**Planning Department
Transportation Development Services**

July 18, 2014

Re: Albuquerque Rescue Mission, 525 2nd St. SW
Traffic Circulation Layout
Architect's Stamp dated 07-08-14 (K14-D057)

① TRAFFIC CIRCULATION LAYOUT
1" = 20'-0"

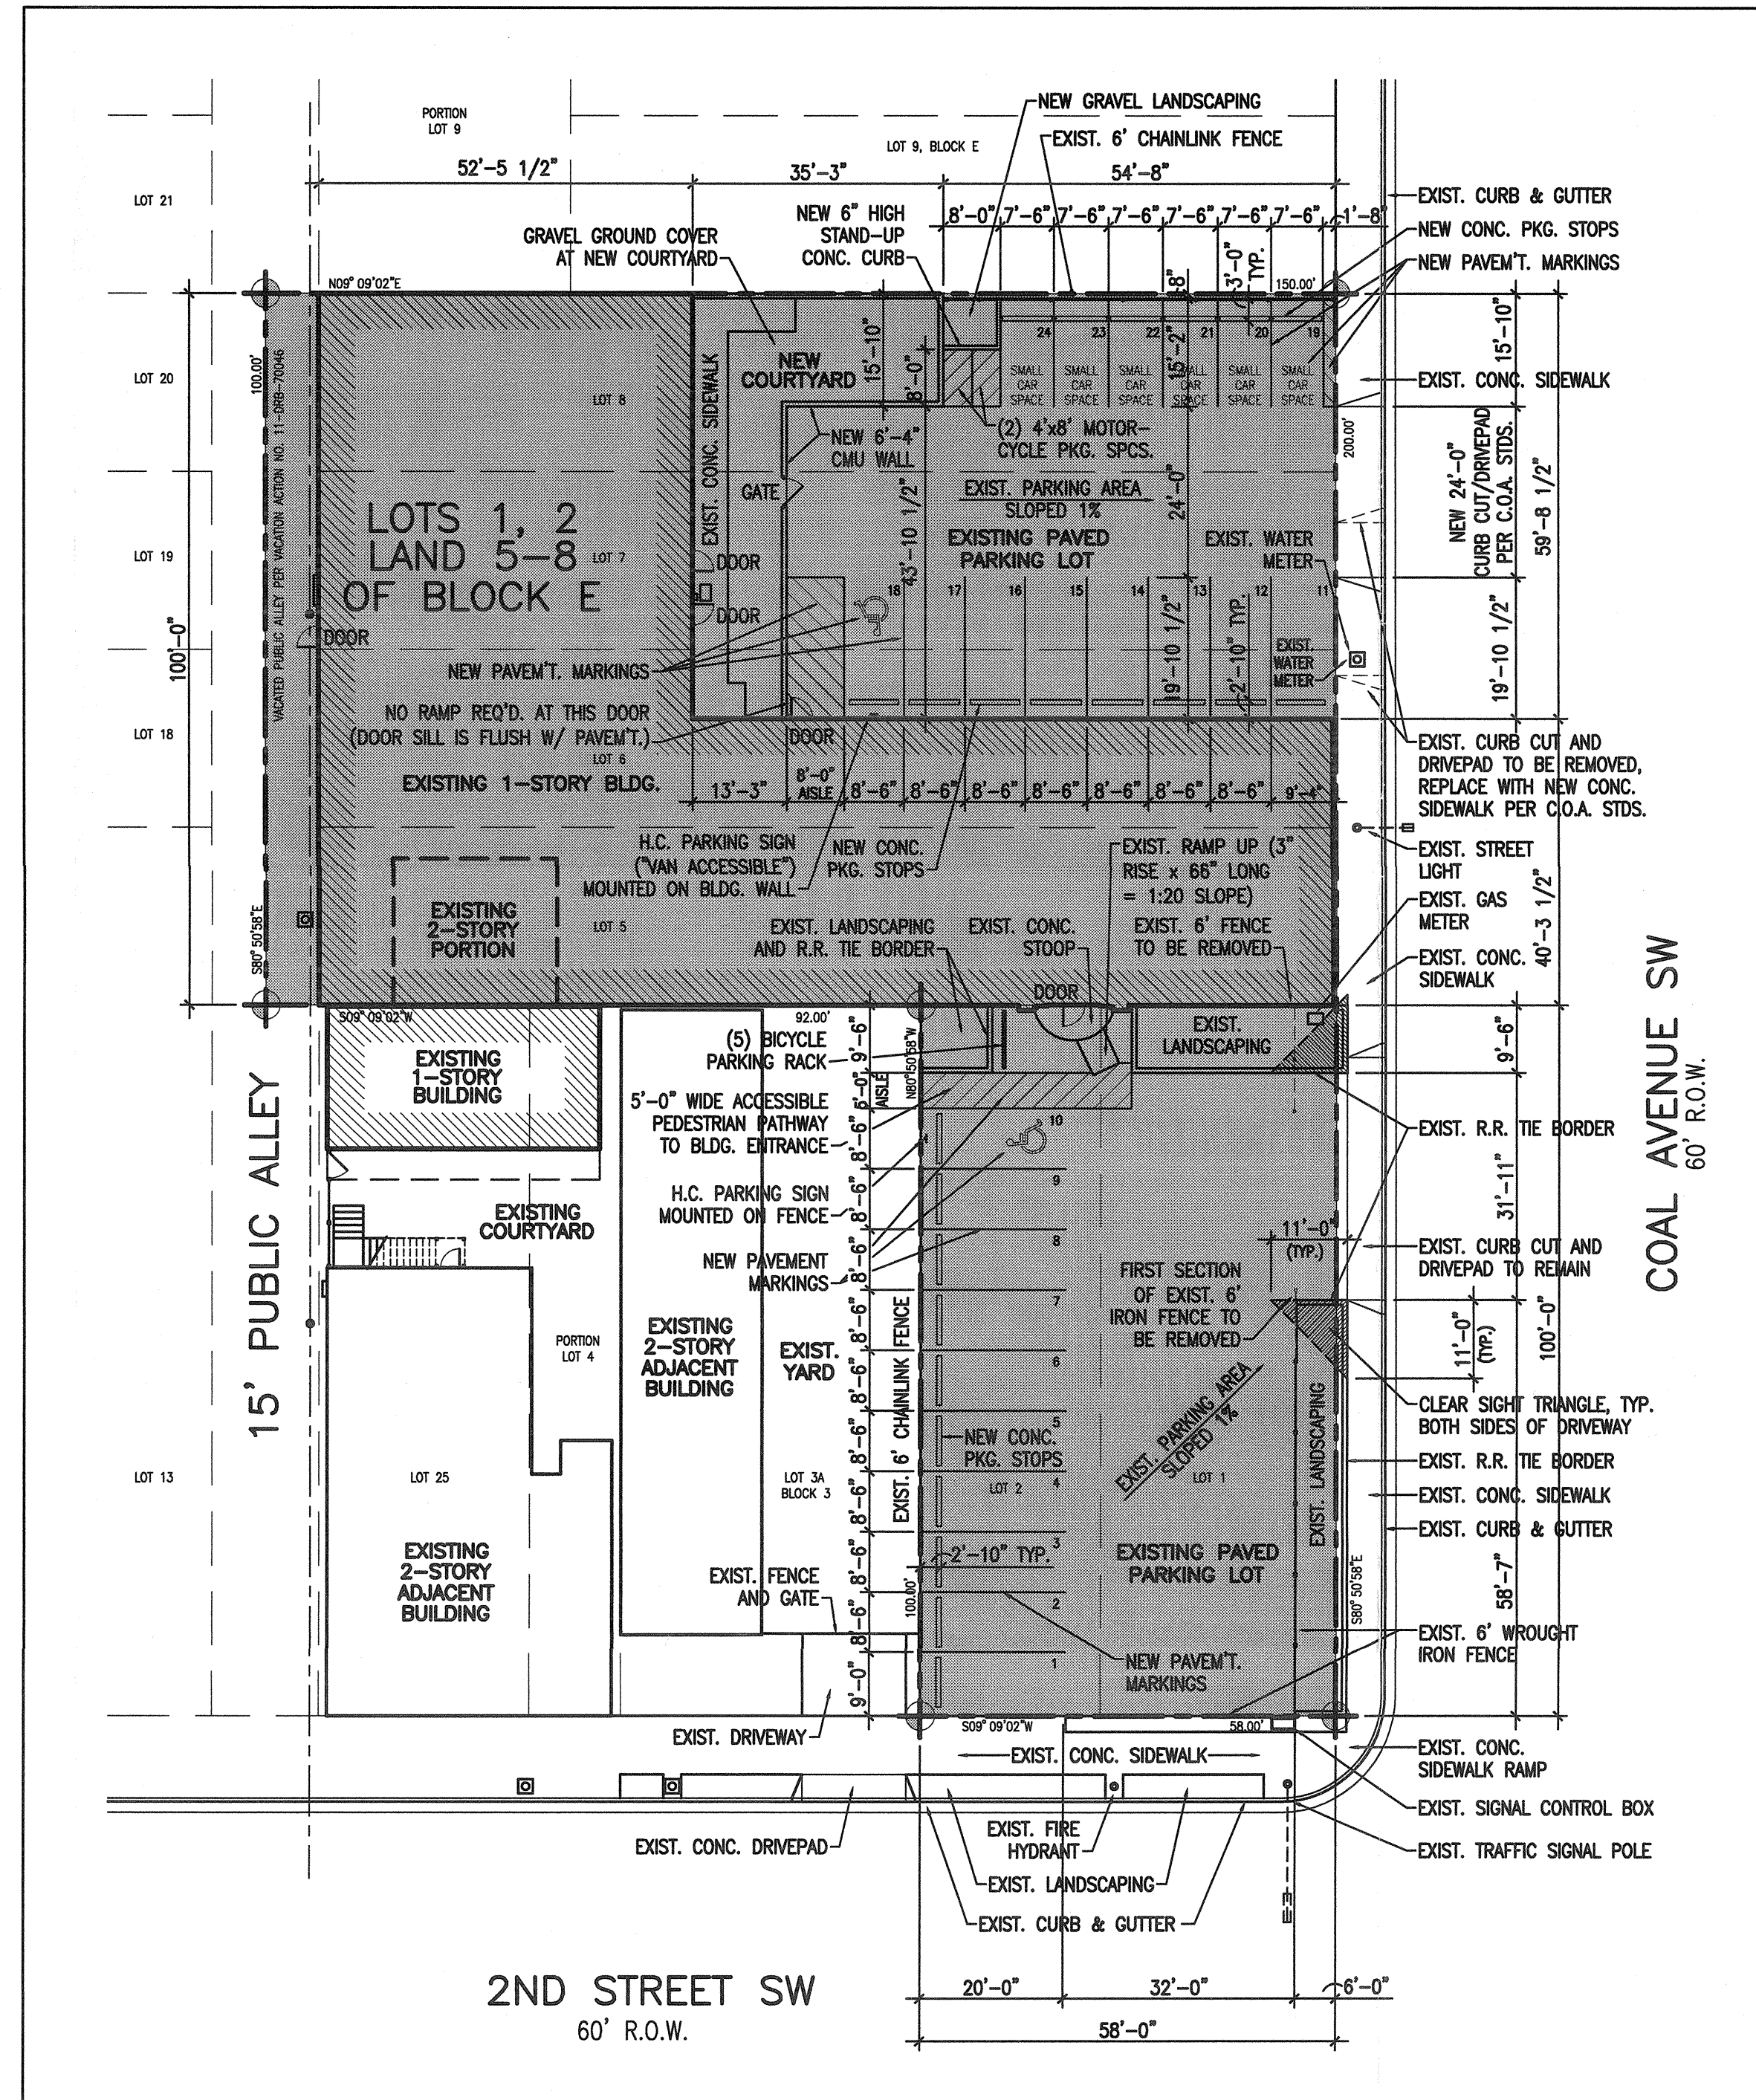
1. The handicapped spaces must be a minimum of 8.5 feet in width. They must include an 8-foot wide van access aisle; all other aisles should be 5 feet in width.
2. Is either of the proposed ADA accessible parking spaces required to be van accessible?
3. Per the DPM, a 6 ft. wide ADA accessible pedestrian pathway is required from the HC parking stall access aisles to the building entrances.
4. Please ensure all ramps are ADA compliant. Is there a ramp to the doorway on the west side of the building next to the proposed ADA parking spot?
5. The existing landscaping or walls may interfere with the sight distance of the intersection. Please provide a sight distance exhibit (see the *Development Process Manual, Chapter 23, Section 6, Part B.12 Visibility for Driveways*).

6. Please add the following note: "Landscaping and signage will not interfere with clear sight requirements. Therefore, signs, walls, trees, and shrubbery between 3 and 8 feet tall (as measured from the gutter pan) will not be acceptable in the clear sight triangle."
7. Please include two copies of the traffic circulation layout at the next submittal.
